March 11, 2025

Re: Panda Express at 2040 Gibson Blvd SE (Lots C-1 & C-2 Lovelace Heights Addition.)
Erosion and Sediment Control Plan (Sheet C06.1)
Engineer's Stamp date 3/5/25 (M15E021F) SWQ-2025-00012

Principal Engineer, Planning Dept.
Development and Review Services

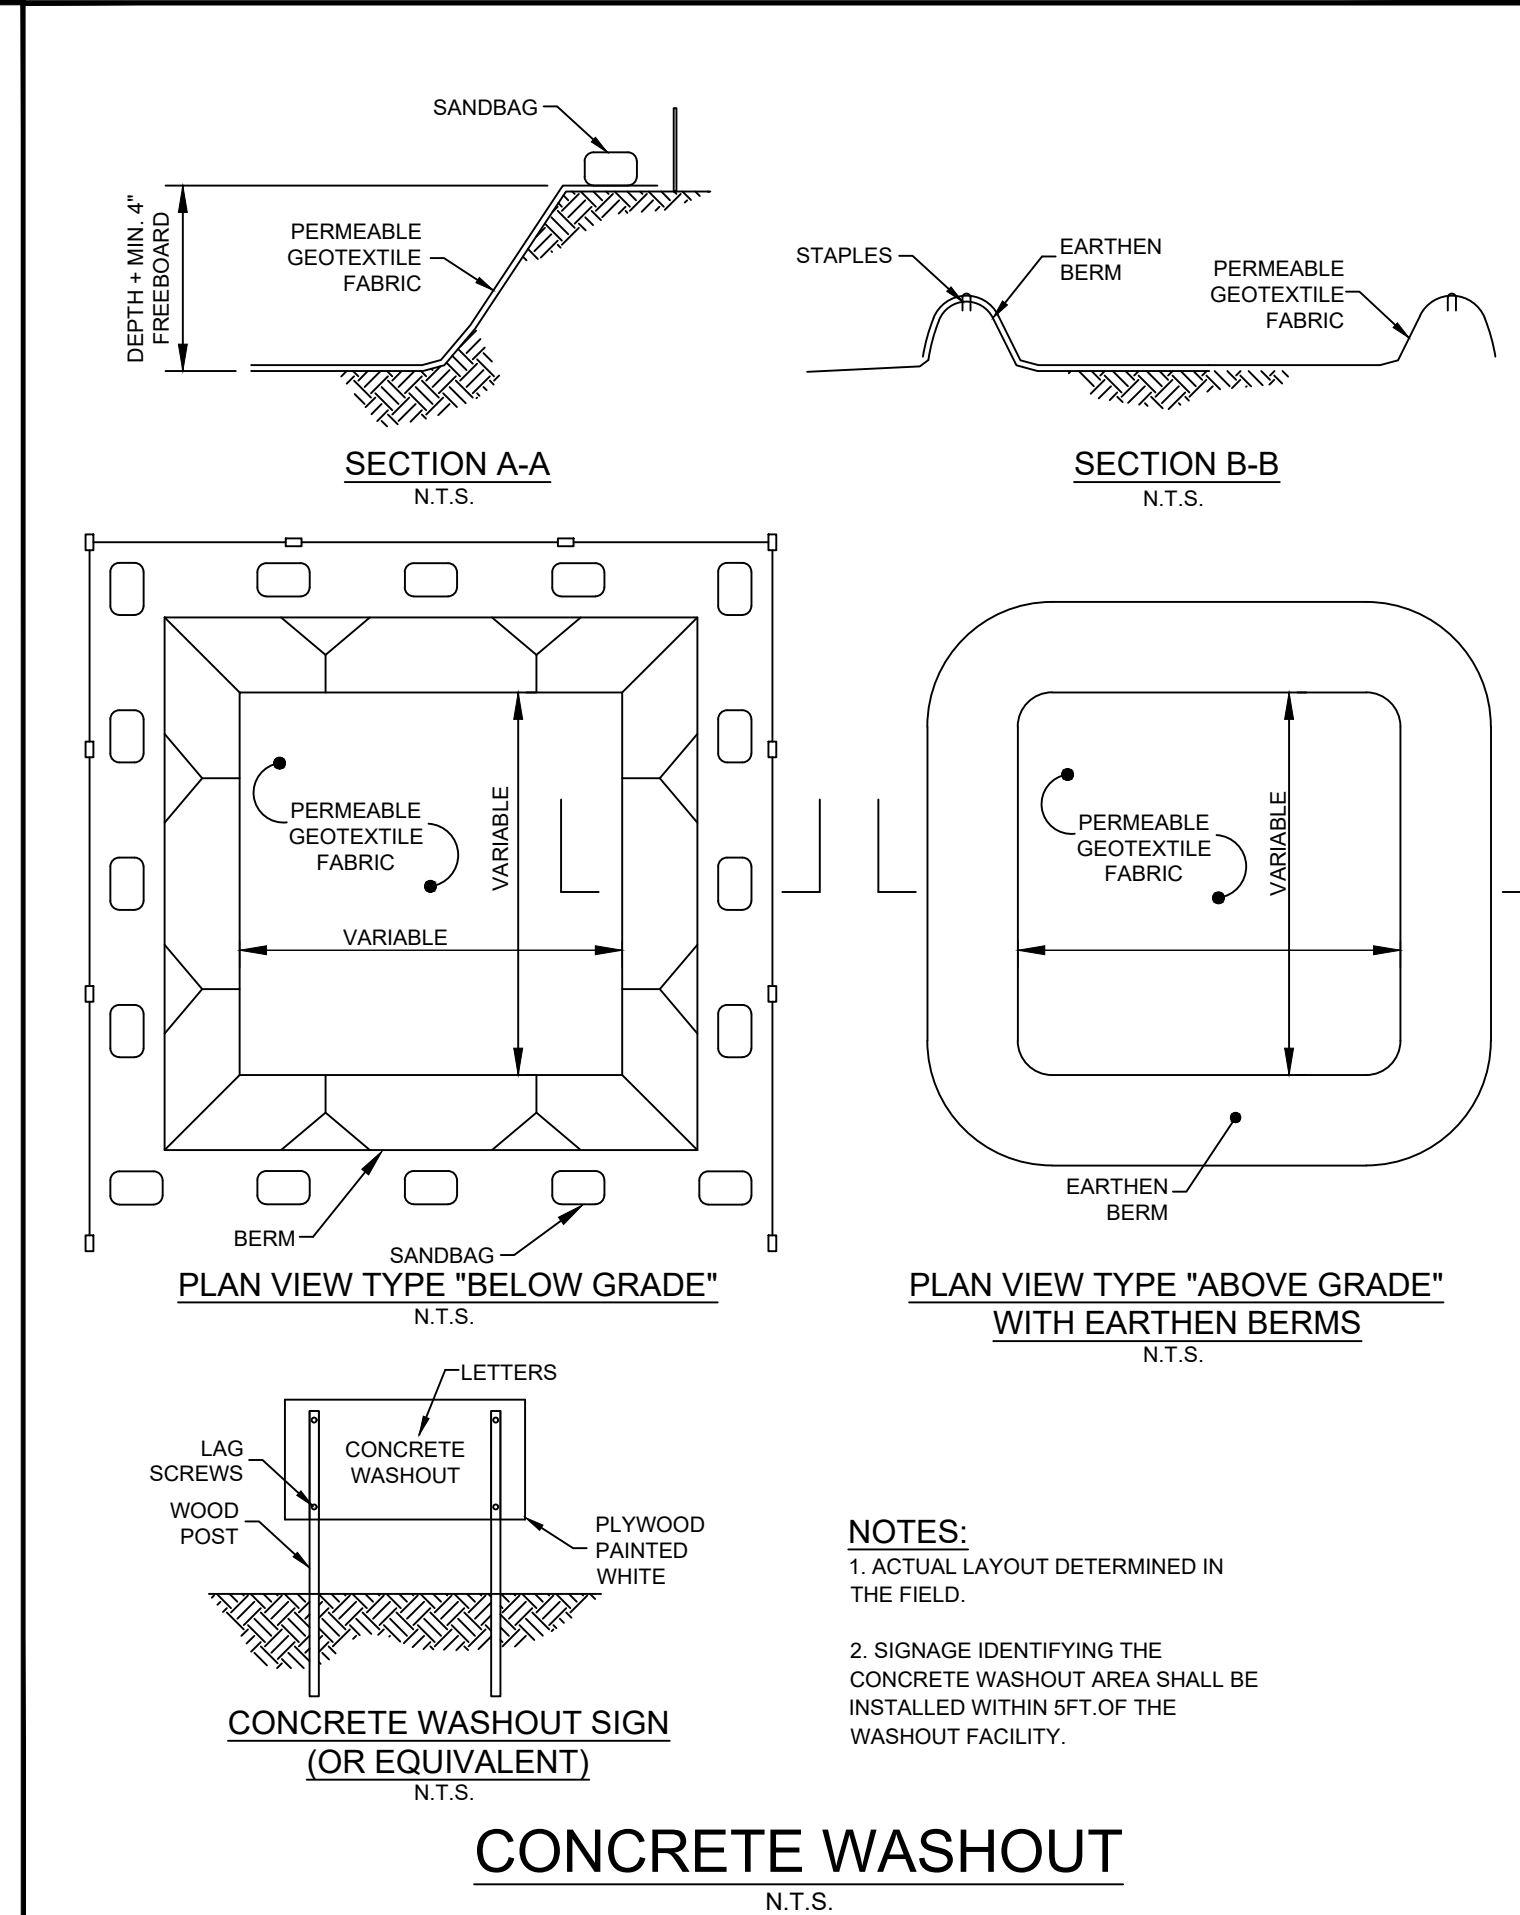
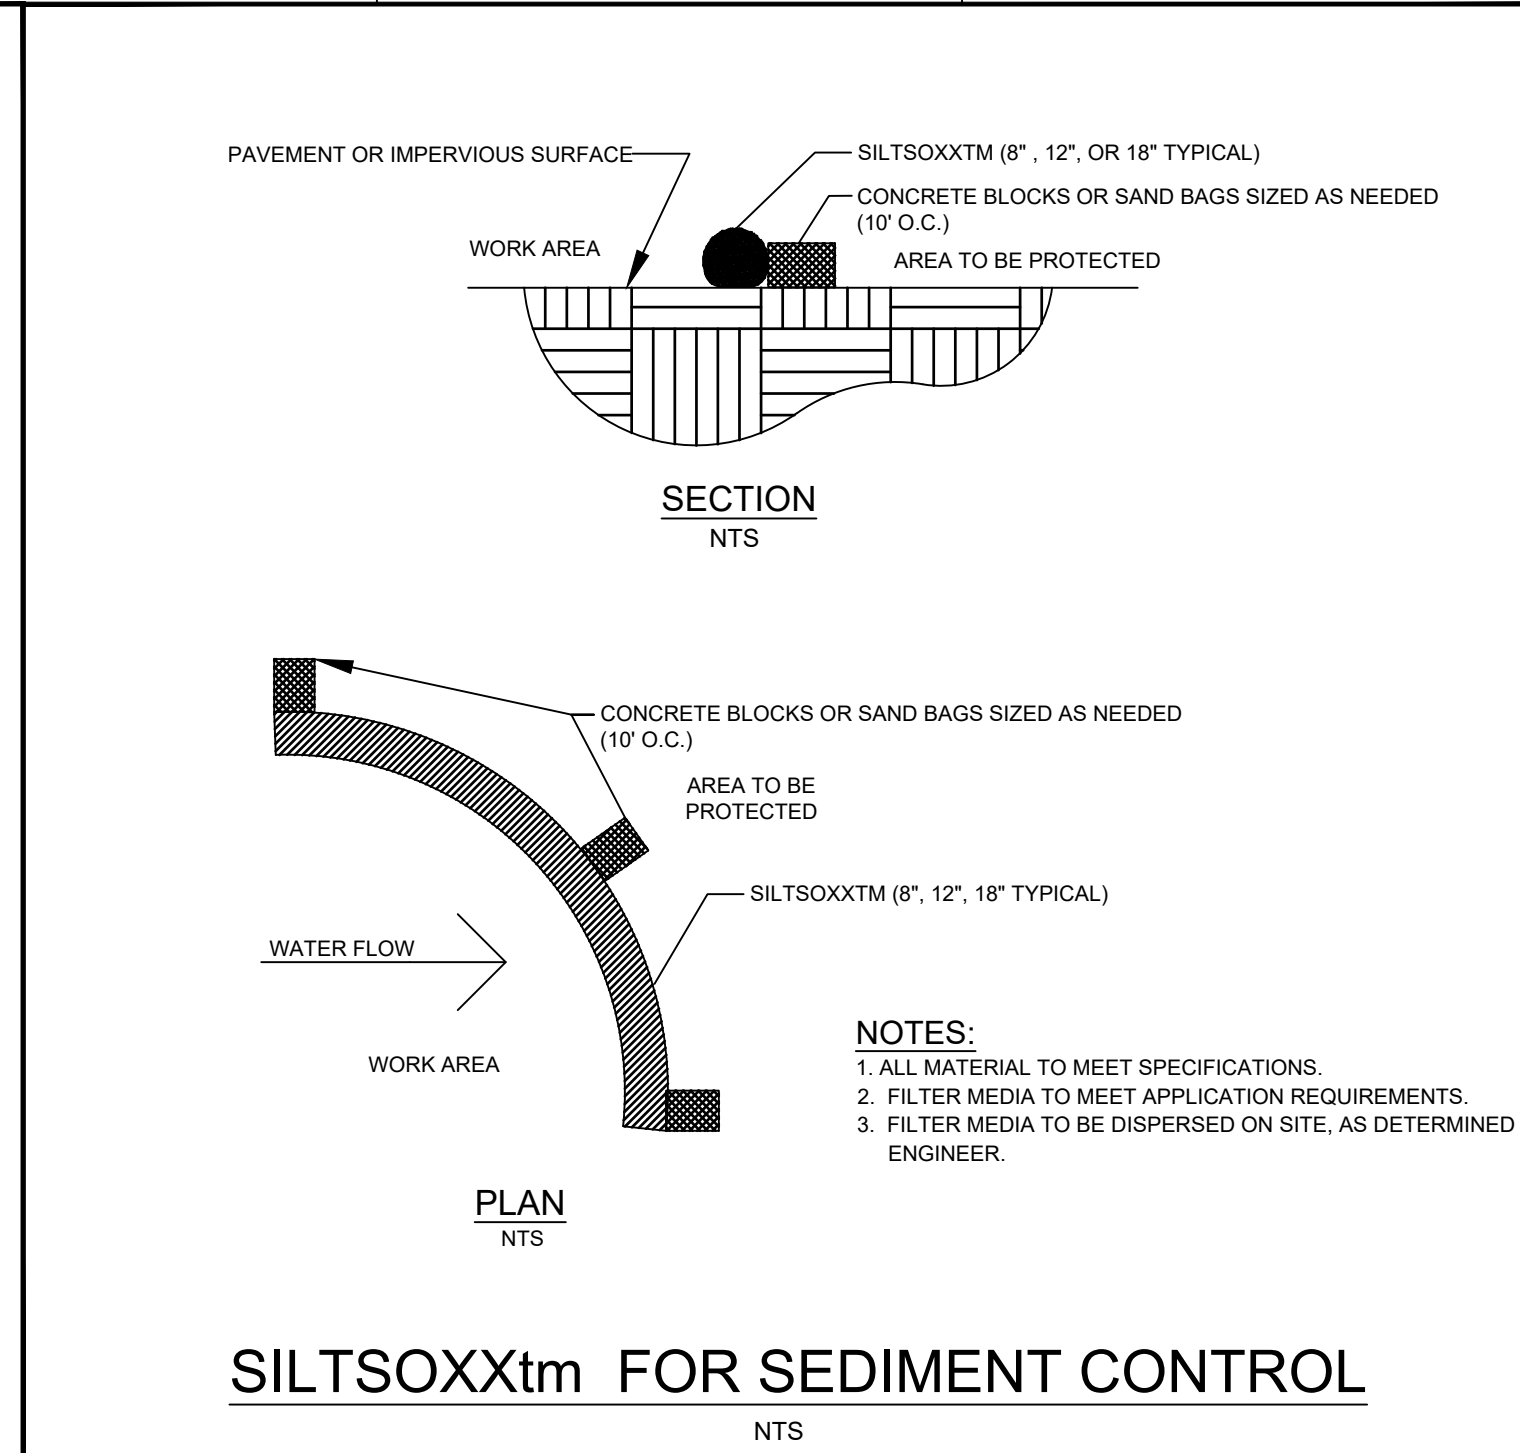
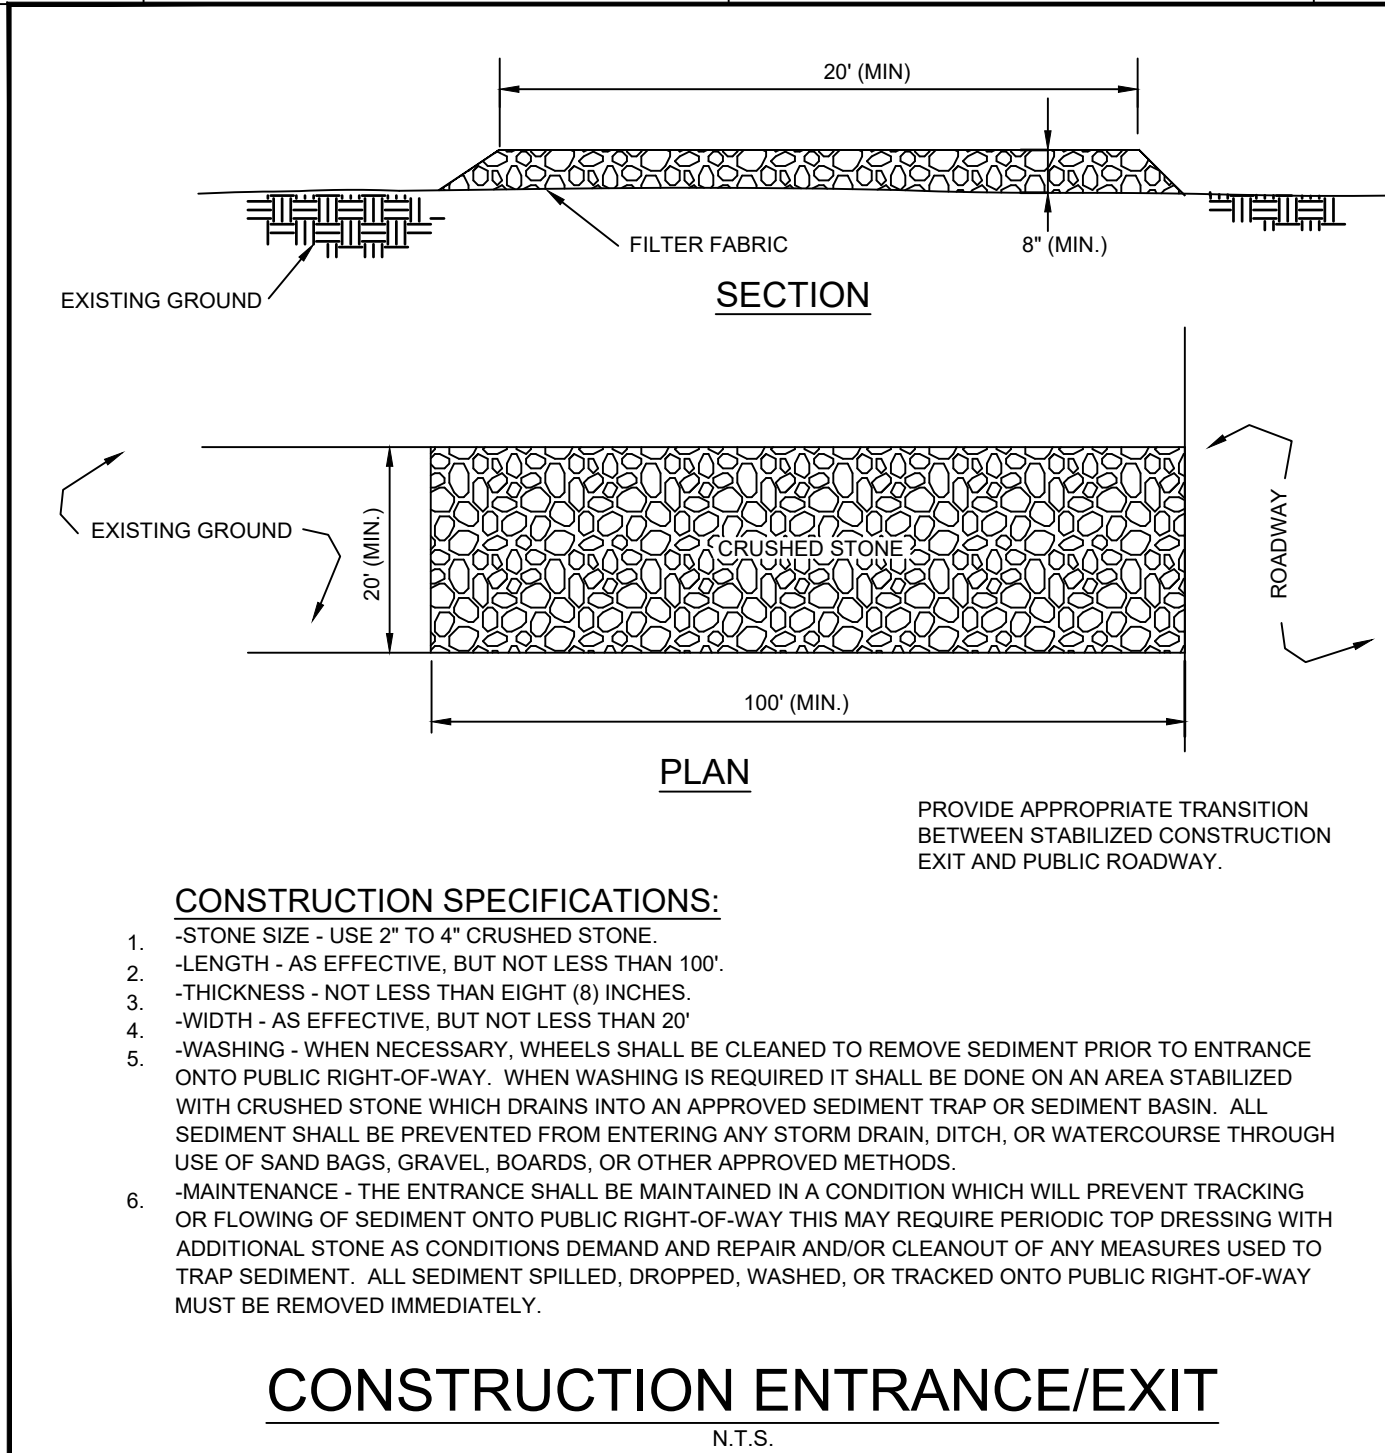
5. The limits of land disturbing activities must include all stockpiles and construction support activities already taking place on the adjacent property, Lot C-1. Also, indicate the areas of control of the two property owners/operators unless all construction support activities are removed from Lot C-1 and the disturbed portions are stabilized with rock per CGP 2.2.14.c.ii before the next City Inspection. **The ESC Plan, Sheet C06.0, was missing from the resubmittal, so the limits of disturbance are unknown.**

6. The BMPs shown are inadequate. Mulch sock, as shown, isn't an acceptable substitute for Silt Fence. Silt Fence must be shown at the limits of disturbance, including the area of construction support activities and offsite stockpile as a dust control per your Fugitive Dust Permit and CGP 2.2.6. However, Silt Fence alone isn't sufficient to manage the stormwater quality requirements where the silt fence is downhill from disturbed areas, and the Silt Fence isn't located on-contour or the Silt Fence is located at concentrated "Discharge Points." You must identify the Discharge Points on the ESC Plan and add Sediment Traps, one each at the southwest and northwest corners of the site. At all locations downhill from disturbed portions of the site where the Silt Fence isn't on contour, you must add Diversion Berms in addition to the Silt Fence. **The ESC Plan, Sheet C06.0, was missing from the resubmittal, so the controls are unknown.**

7. Construction details and specifications are missing from the ESC Plan for most of the stormwater controls, including but not limited to Stockpile Management, Silt Fence, Diversion Berms, and Sediment Traps. NMDOT has details for most of these BMPs at [NMDOT NPDES Manual Rev 4 2023](#) in Appendix A. Mulch socks don't seem appropriate, but if used, they should be staked per NMDOT detail instead of weighted down. **The ESC Plan, Sheet C06.0, was missing from the resubmittal, so the controls are unknown.**
